Please ask for: Mrs D Johnson
Email: daun.johnson@arun.gov.uk
Telephone: 01903 737762
Our Ref: EP/164/21/PL
Your Ref:
Date: 9th December 2021

Application for Planning Permission

Development: Installation of 3 No LED lights, attached to three 5 m columns (resubmission of EP/156/20/PL). This site is in CIL Zone 4 (Zero Rated) as other development.
Location: Warren Recreation Ground Car Park 40 Sea Road East Preston BN16 1JP

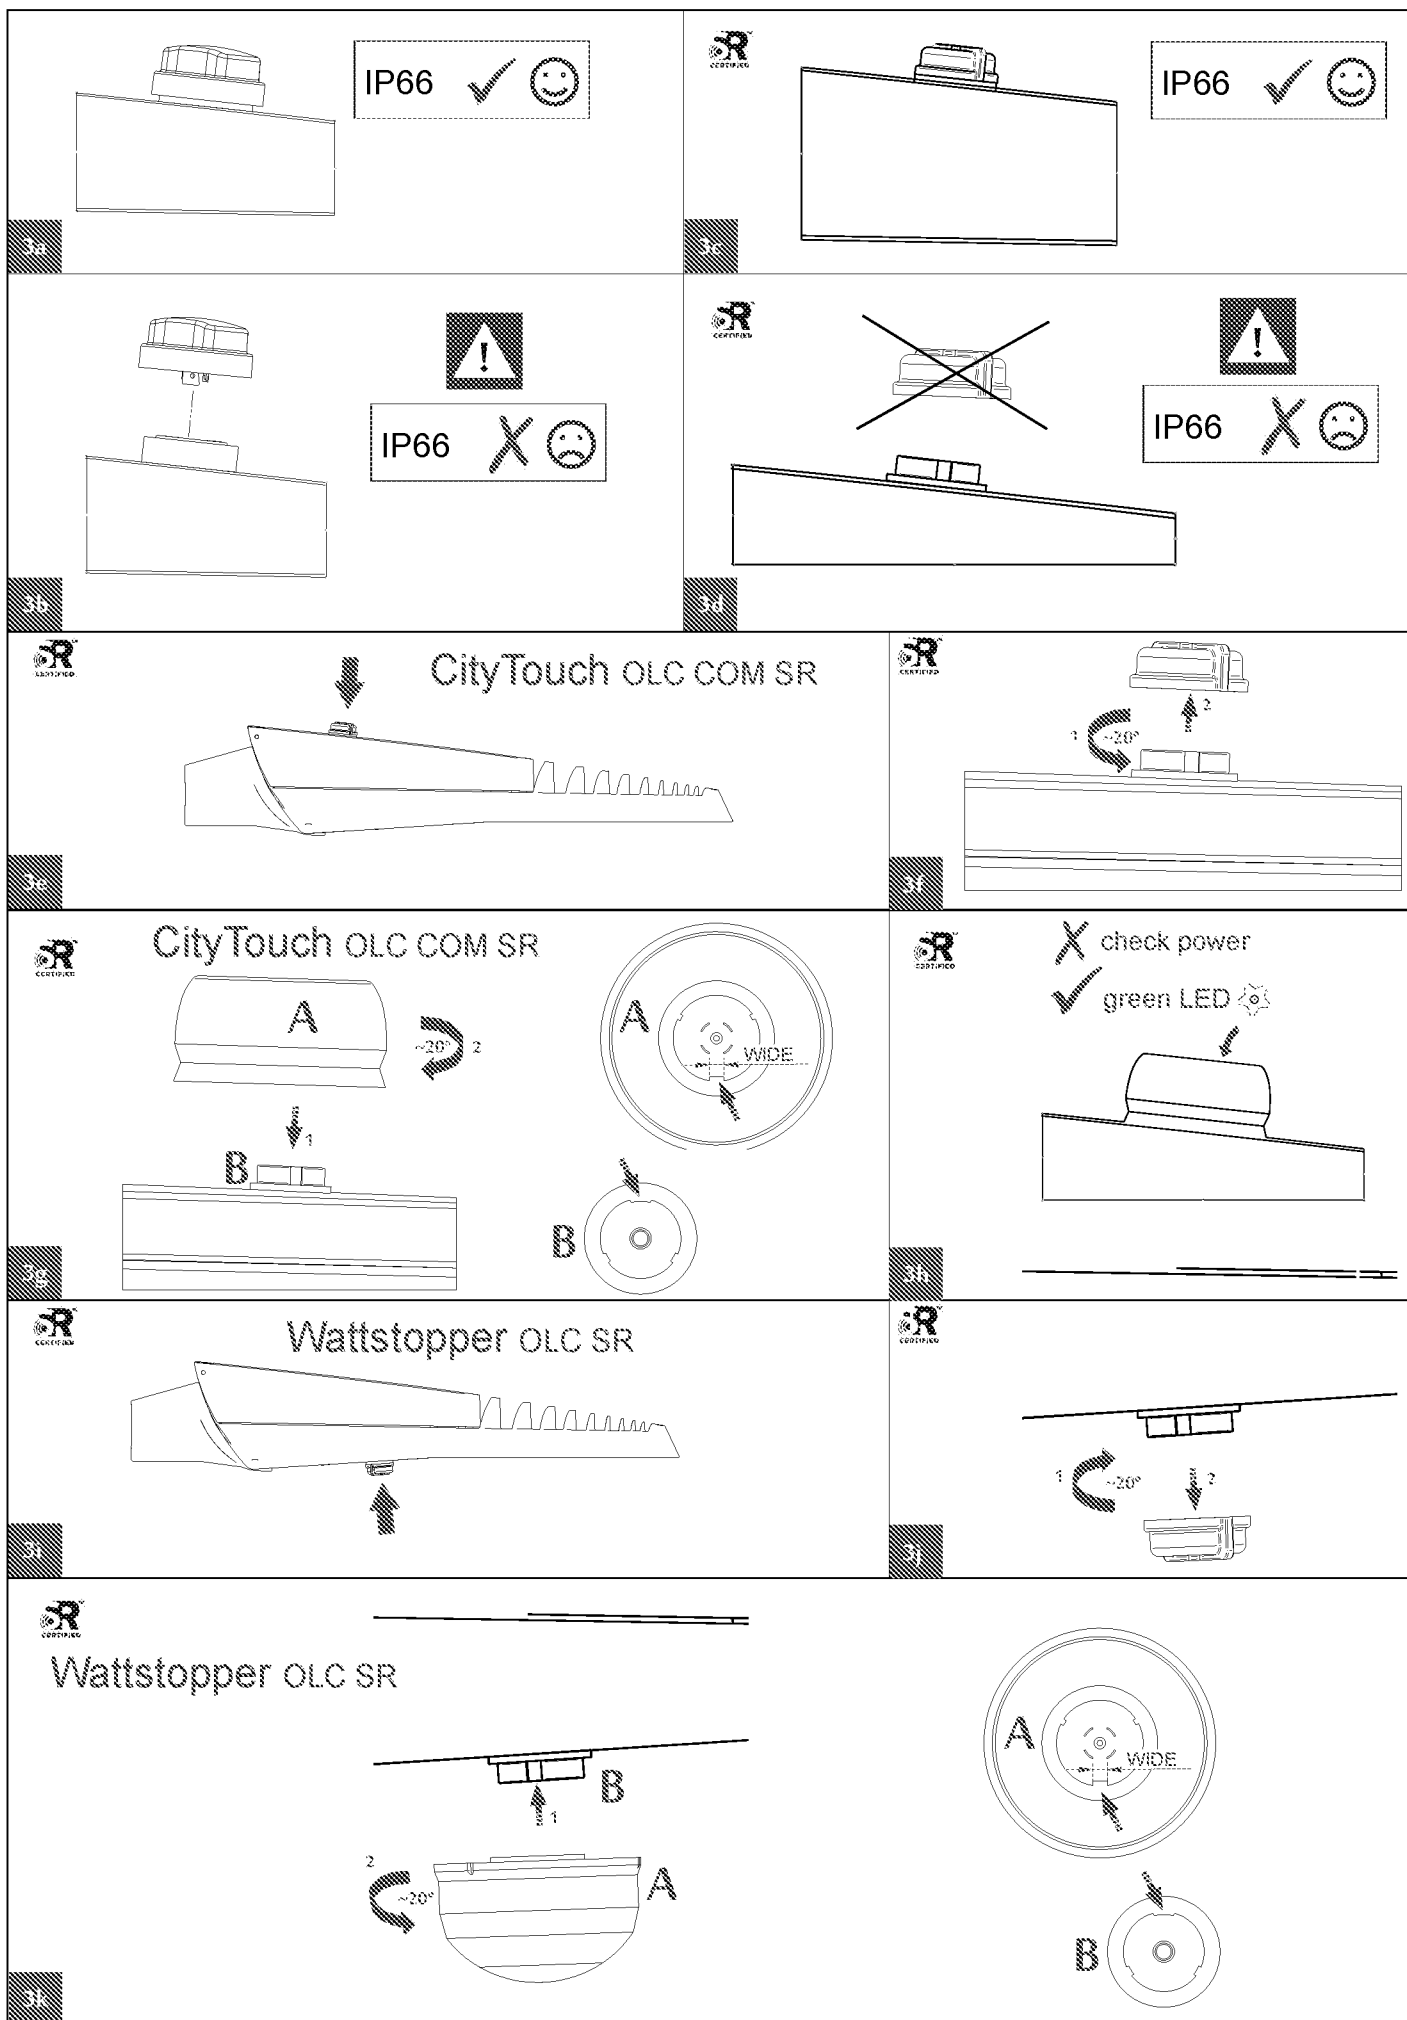
Please provide details of the solar lights.

CAR PARK STREET LIGHTING LAYOUT DRAWING

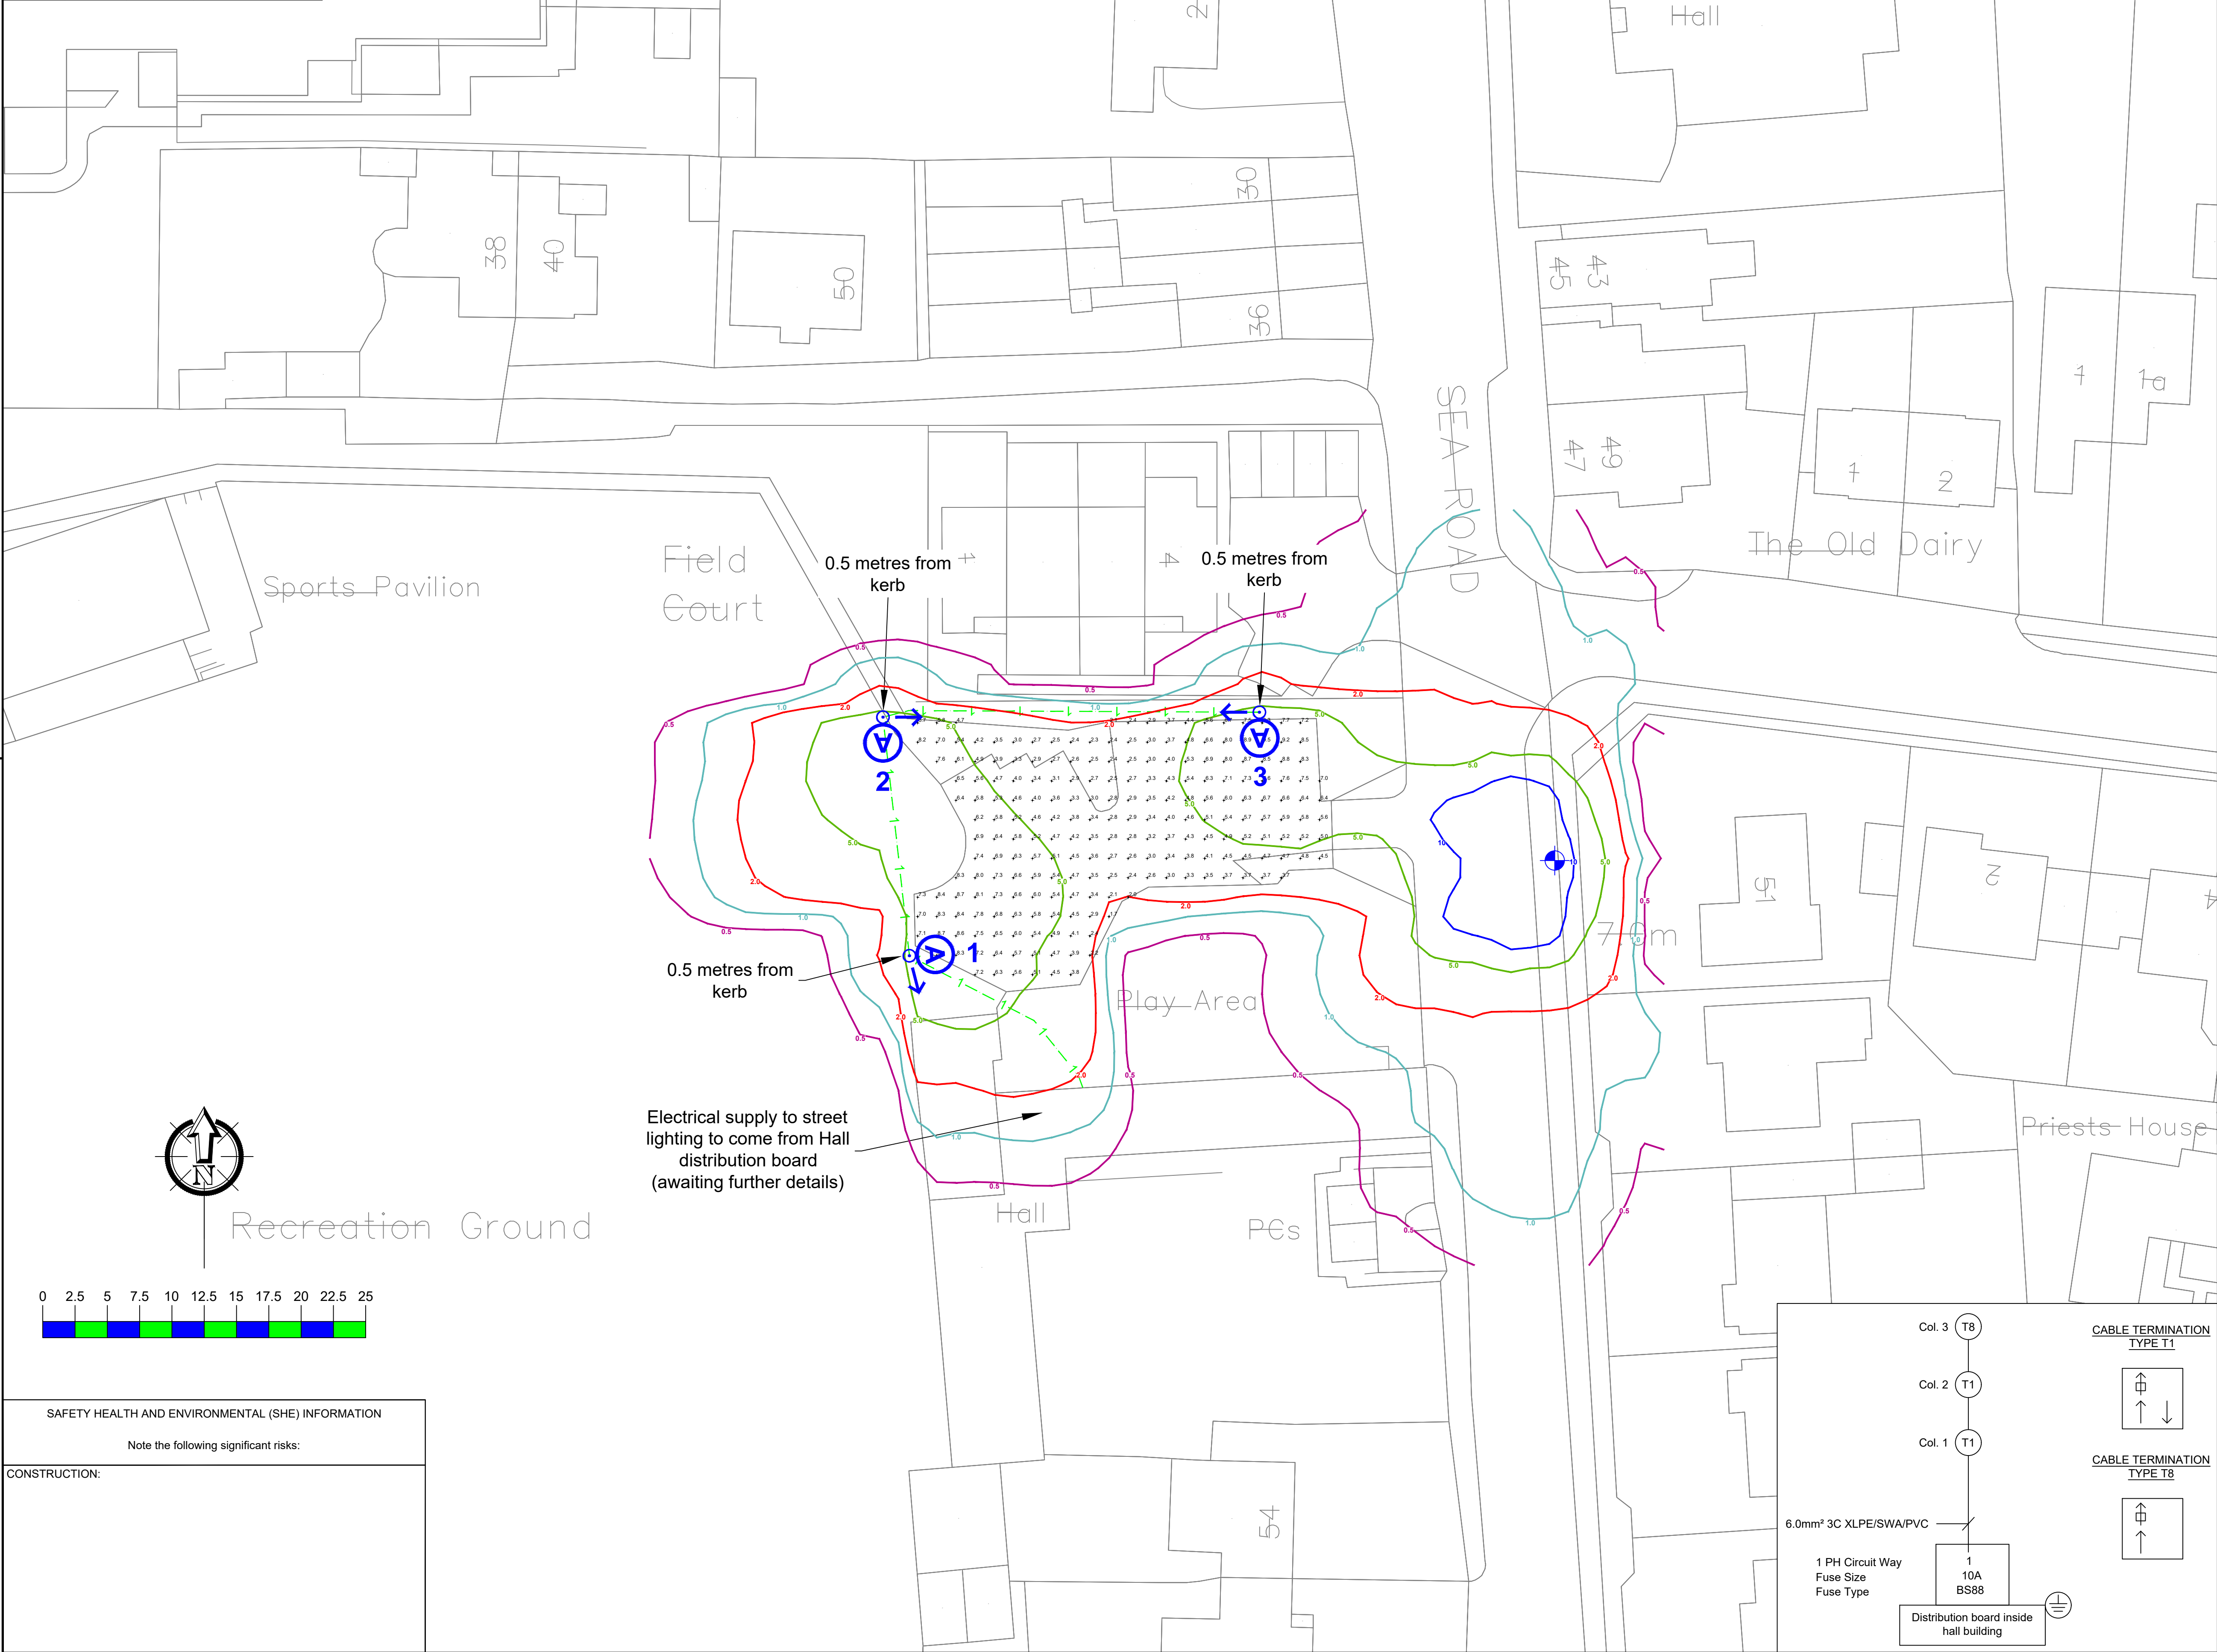
Block Plan

Please provide a north point and highlight the location of the proposed works.
